ASSESSMENT REPORT

3 MURRAY ROSE AVENUE, SYDNEY OLYMPIC PARK MP 11_0082 MOD 2

Project Title		Write Here	
3 MURRAY ROSE AVENUE Sydney Olympic Park			
Drawing Title			
GA Elevations North Elevation			
Scale	Project No.	Drawn by	North
1:100 @ B1	11002	GB	
Sheet	Dwg No.	Rev	
CONSTRUCTION	ADB 35104	H

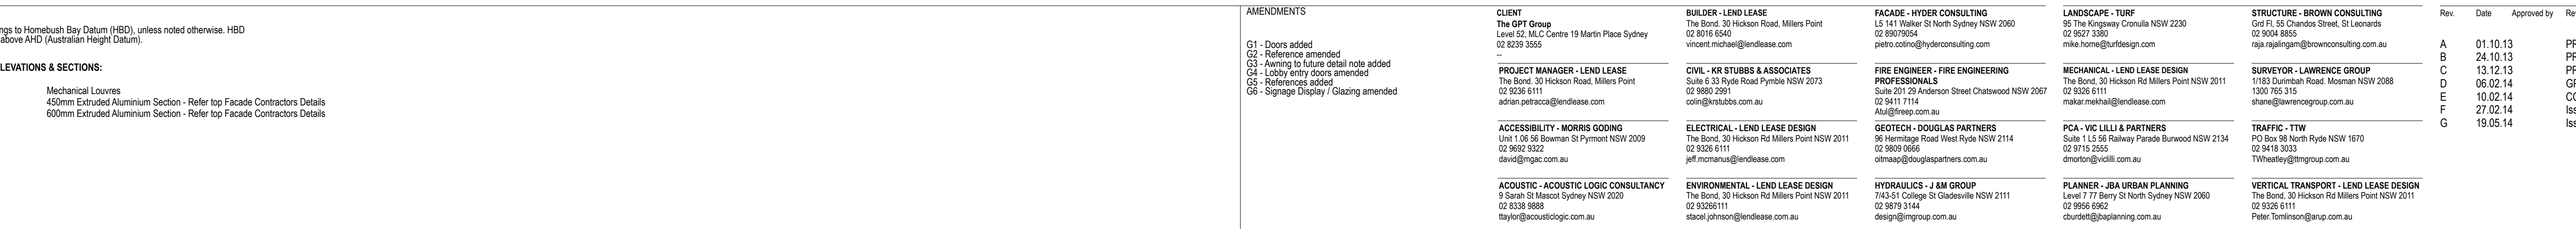
- the gradient of the access ramp to the bicycle parking should not exceed 25%; and
- the upper level sign on the northern elevation (sign number six) should be deleted to reduce the impact on the adjacent parkland and to be consistent with the adjacent building at 5 Murray Rose Avenue.

SOPA raised concerns that the total number of signs was excessive and recommended that the parapet level sign (2500mm x 500mm) on the northern elevation facing the parklands (Brickpit Park) be deleted.

The proponent has confirmed that it has no objection to the removal of the parapet level sign on the northern elevation.

The Department recommends that the proposed northern elevation plan (which includes the parapet level sign to be removed, as discussed above) not be included as part of the updated drawing list at condition A2. The Department also recommends a new condition that requires the signage to comply with appropriate design and maintenance standards.
